M60/M62/M66 Simister Island Interchange

TR010064

**APPLICANT'S RESPONSES TO EXAMINING AUTHORITY'S RULE 17
LETTER DATED 28/01/25**

Version	Date	Status of Version
P01	11 February 2025	Deadline 6

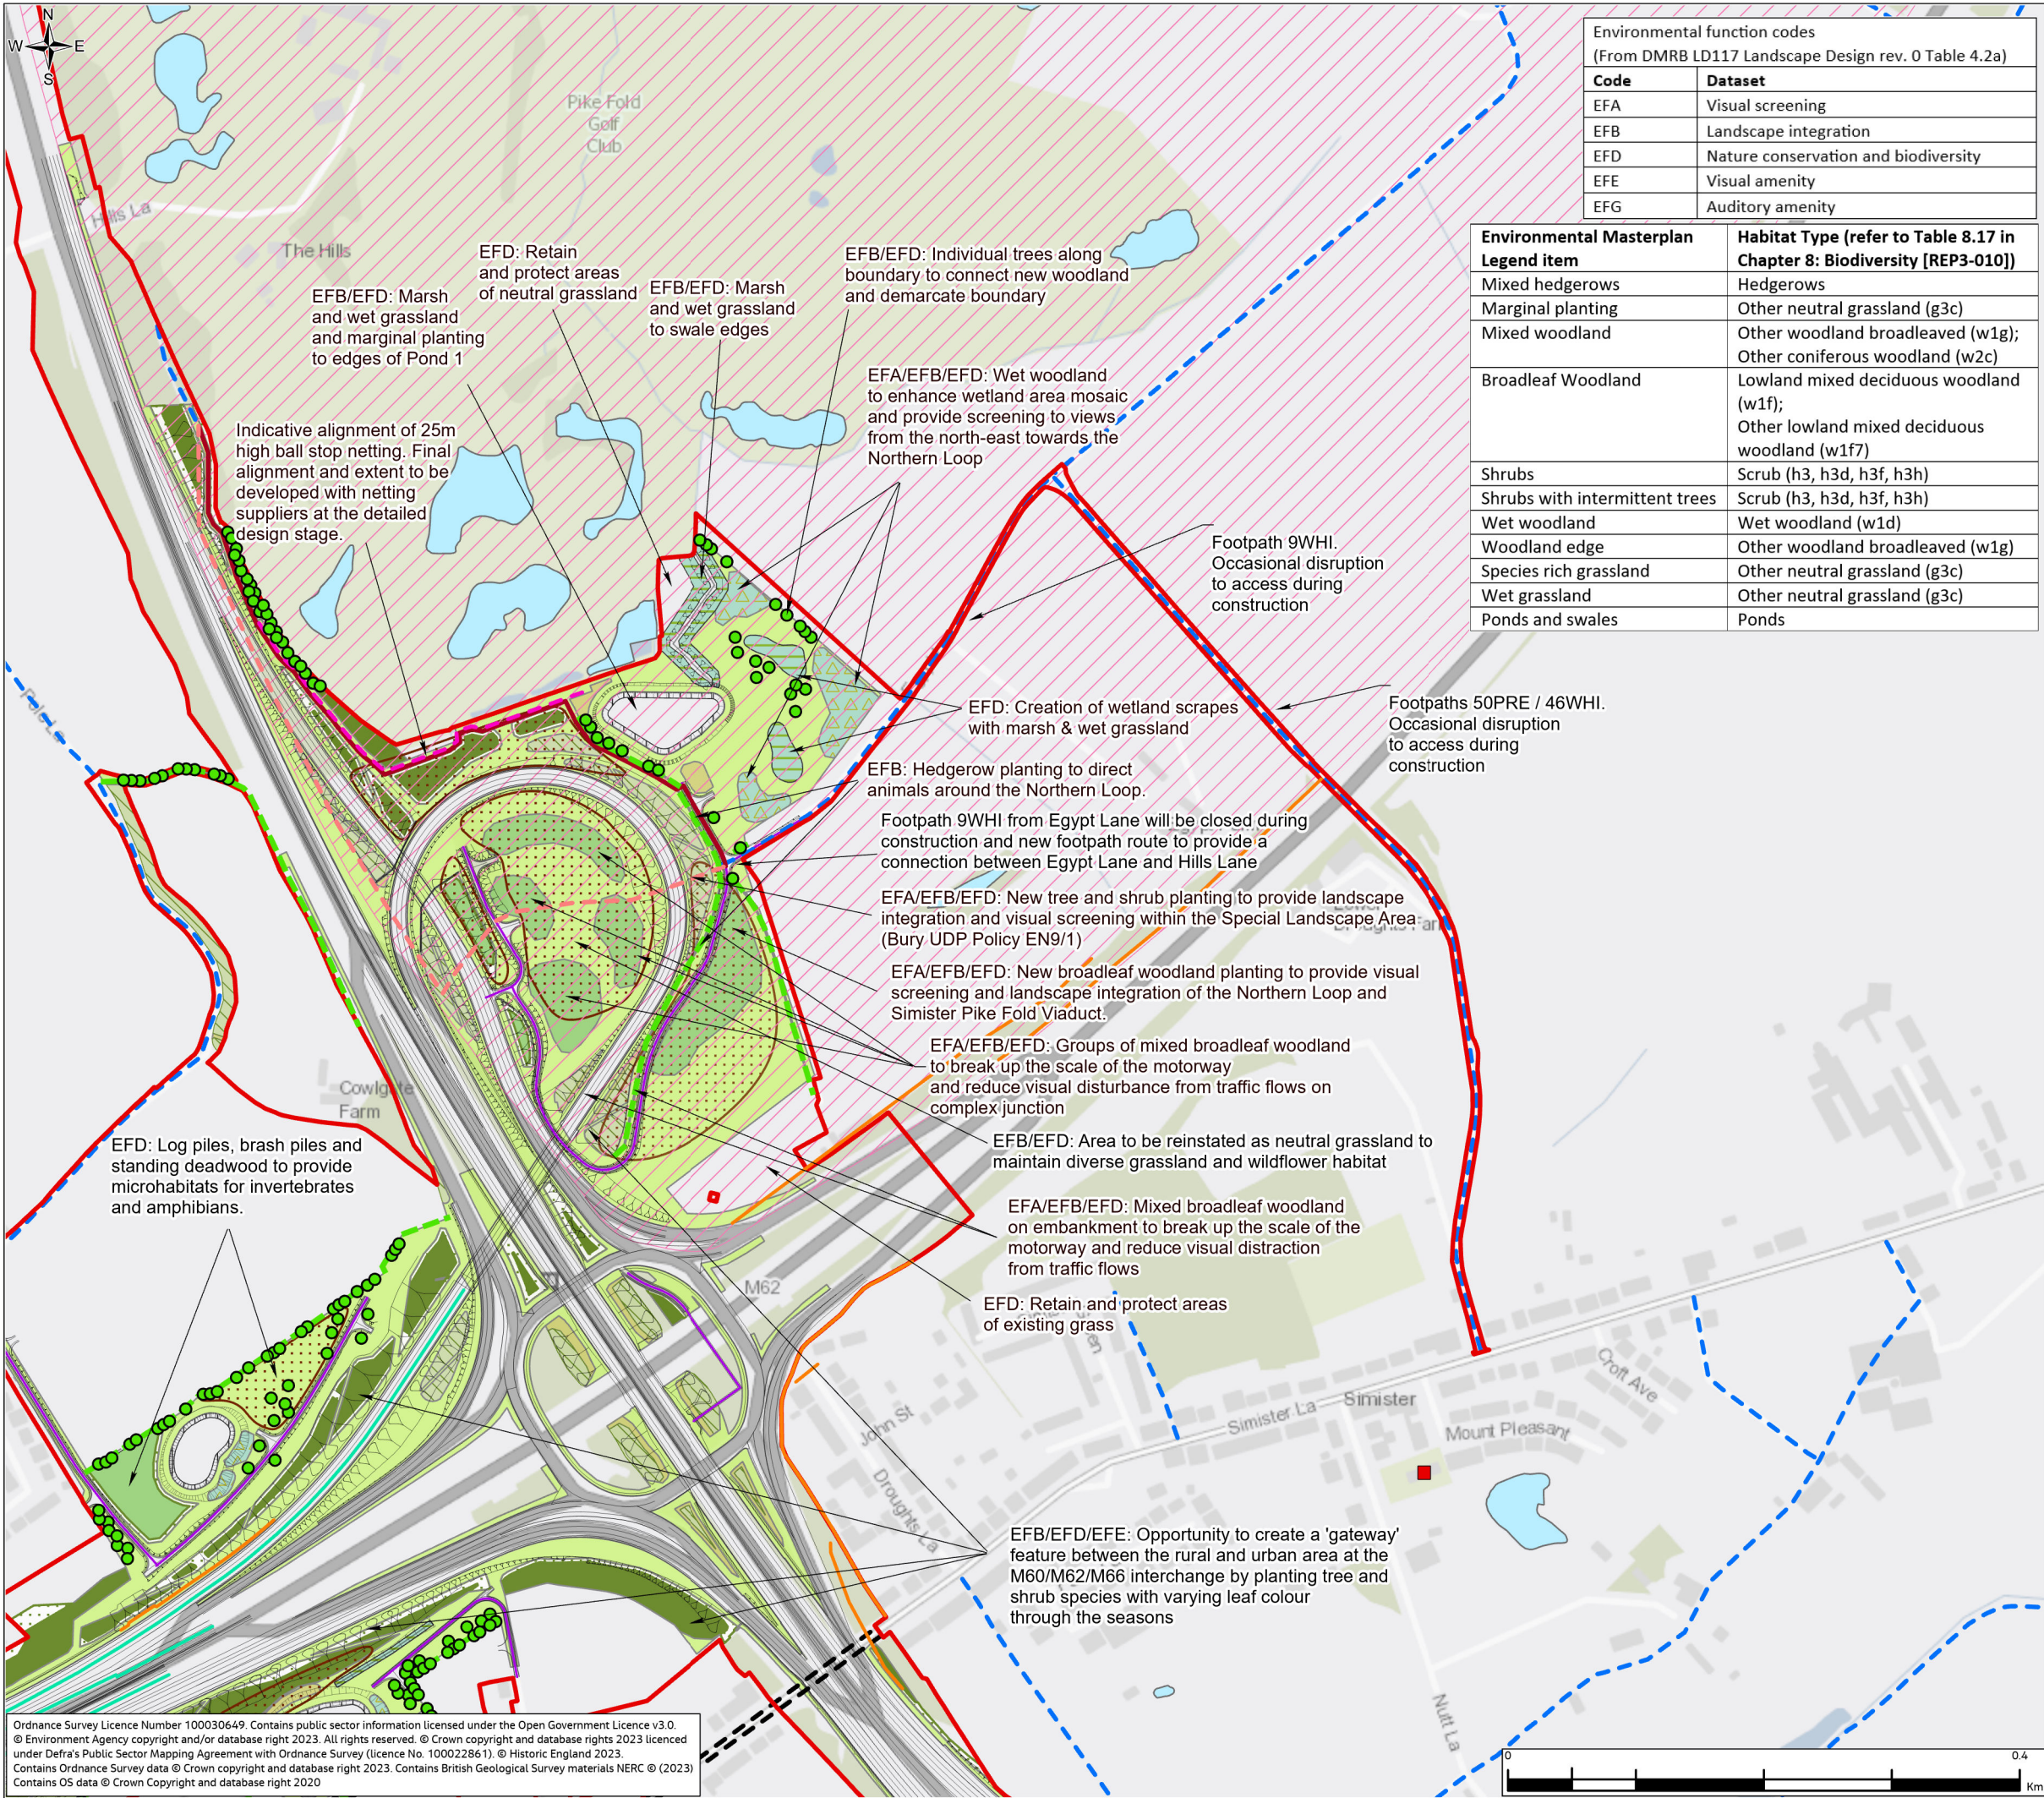
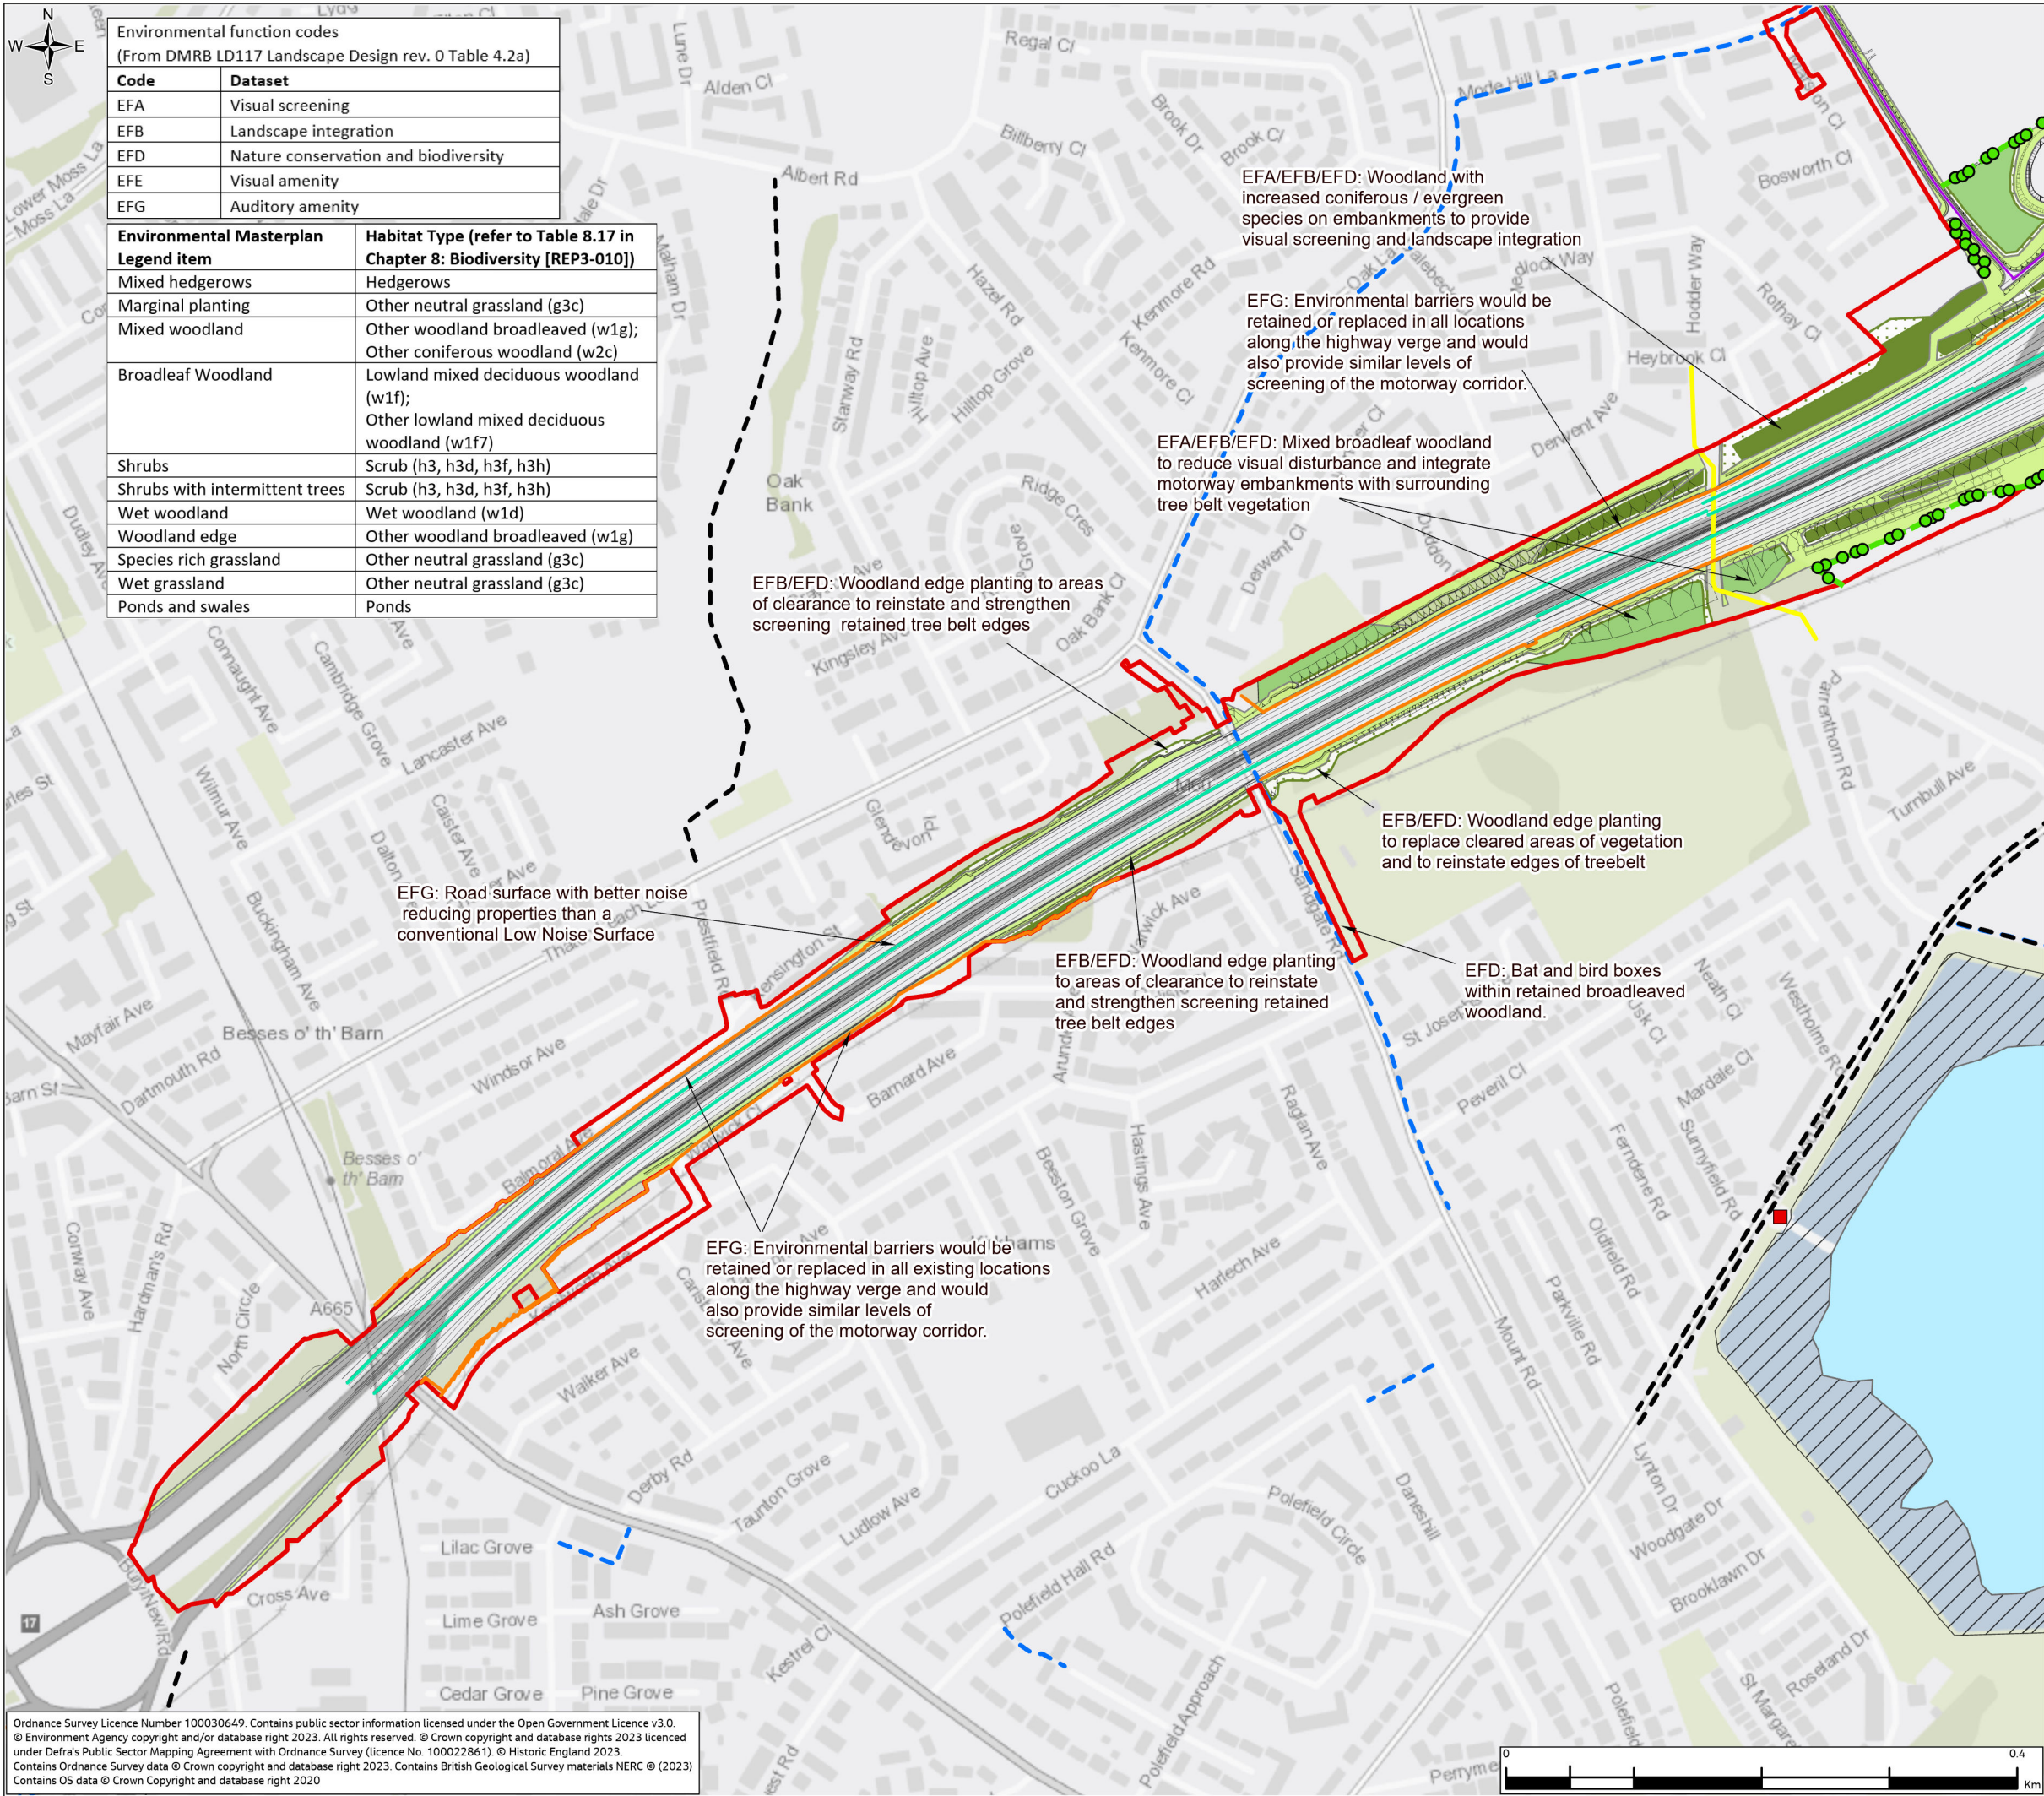
R.8.2	Applicant	<ul style="list-style-type: none"> Confirm the environmental function code for the broadleaf woodland proposed in land plot 2/16b on [REP5-017]. 	<p>The Applicant confirms with reference to Sheet 3 of Figure 2.3 Environmental Masterplan of the Environmental Statement Figures [REP5-017], the environmental function code for the broadleaf woodland planting plot located in Plot 2/16b (as shown on the Land Plans [REP3-004]) south-east of the Northern Loop, is EFA/EFB/efd. This illustrates the environmental mitigation's provision for Visual screening (EFA), Landscape integration (EFB) and Nature conservation and biodiversity (efd). The broadleaf woodland planting provides visual screening and landscape integration of the Northern Loop and Pike Fold Simister Viaduct. This erroneously omitted function code label will be added to Figure 2.3 Environmental Masterplan of the Environmental Statement Figures [REP5-017] for Deadline 7.</p>

R.8.6	Applicant	<ul style="list-style-type: none"> Figure ExQ2 BIO2.2 [REP5-033] identifies an area within plots 2/16b and 2/16d as 'habitats to be enhanced'. However, Figure 2.3 [REP5-017] annotates these areas for nature conservation and biodiversity purposes to 'retain and protect areas of existing grass'. Explain how these areas can be considered an enhancement if they are proposed to be retained and protected. In addition, explain further why an existing area to be retained and protected requires compulsory acquisition. 	<p>The area of habitat within plot 2/16d shown on Figure 2.3 Environmental Masterplan [REP5-017] would be retained and protected during construction so there would be no impacts to this habitat. Following creation of new grassland around this retained habitat parcel (within the wider parts of plot 2/16d and also plot 2/16b), both the areas of new grassland, and the area of retained grassland would be managed in accordance with Appendix N: Outline Landscape and Ecology Management Plan [APP-141]. Management of the retained habitat in accordance with that Management Plan is expected to result in an improvement in the condition of the habitat (which is currently poor) and is considered as an enhancement.</p> <p>As stated in paragraph 2.3.17 of Appendix 8.12 Biodiversity Net Gain Report [APP-102], enhancement has been limited to a single step increase in condition (i.e.. poor to moderate) in order to ensure the enhancement is achievable. This is considered appropriate as the grassland (and woodland) currently present in that area will be under the same management regime as the areas of habitat creation to meet the condition criteria outlined within the Biodiversity Metric 3.1 Technical Supplement (Crosher et al., 2022).</p> <p>The area of habitat shown as retained and protected within plot 2/16b on Figure 2.3 Environmental Masterplan [REP5-017] requires compulsory acquisition to enable the Applicant to develop the Scheme detailed design including landscaping and, during operation, implement the management regime described in Appendix N: Outline Landscape and Ecology Management Plan [APP-141] whilst maintaining 'corridors' through the environmental mitigation in this area for access and maintenance of deep drainage associated with drainage network 1. Access and maintenance will also be required for an existing power supply to the communications mast which crosses plot 2/16b from plot 2/16c, which benefits from existing and retained surface access.</p>
